# HAYES STRUCTURAL

**Date:** April 7, 2025

**Re:** 25-FRM-068  
Framing Inspection  
Lot 180 Serenity  
742 Serenity Walk Parkway  
Fuquay-Varina, NC 27526  
Permit No.: SFD2501-0023

Job	Truss	Truss Type	Qty	Ply	DREES HOMES-SERENITY LOT #215 REBUILDS
25-0099-B	M03	Monopitch	10	1	Job Reference (optional)

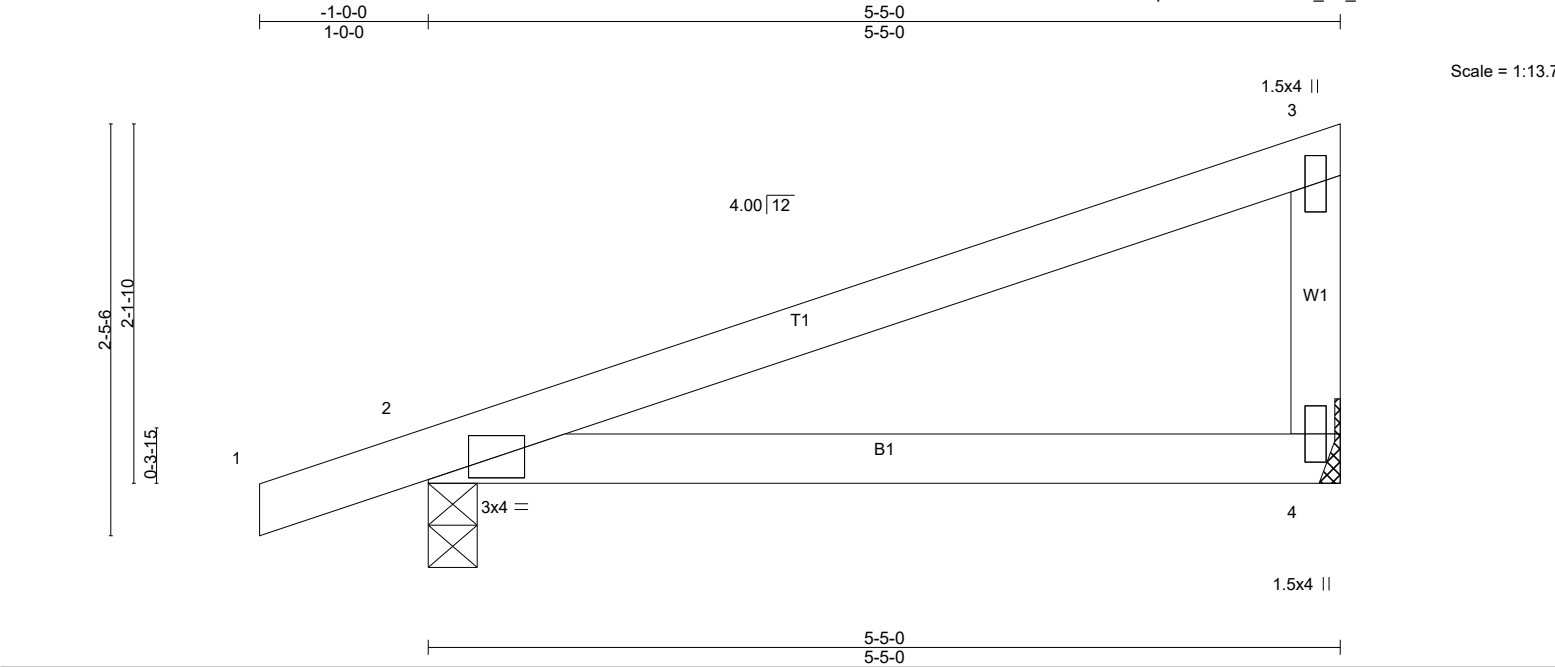
1. The first truss from the left gable end above the left rear bedroom on the second floor (labeled "T02") has a cracked bottom chord (labeled "9-10").
2. The fifth and sixth trusses from the left gable end above the left rear bedroom on the first floor (labeled "M03") each have a broken web (labeled "7-11").
3. The first roof truss from the front gable end above the garage (labeled "T04") has a minor crack in the top of the vertical web at the right end (labeled "4-8").

1. Reinforce the cracked bottom chord with a 2x4x4'-0" scab installed on one side centered on the damage and fastened with (2) rows of 10d nails spaced 4" o.c.
2. Reinforce each broken web with a 2x4x8'-0" scab installed on one side centered on the damage and fastened with (2) rows of 10d nails spaced 4" o.c.
3. Reinforce the cracked vertical web with a full-length 2x4 scab installed on one side and fastened with (2) rows of 10d nails spaced 4" o.c.
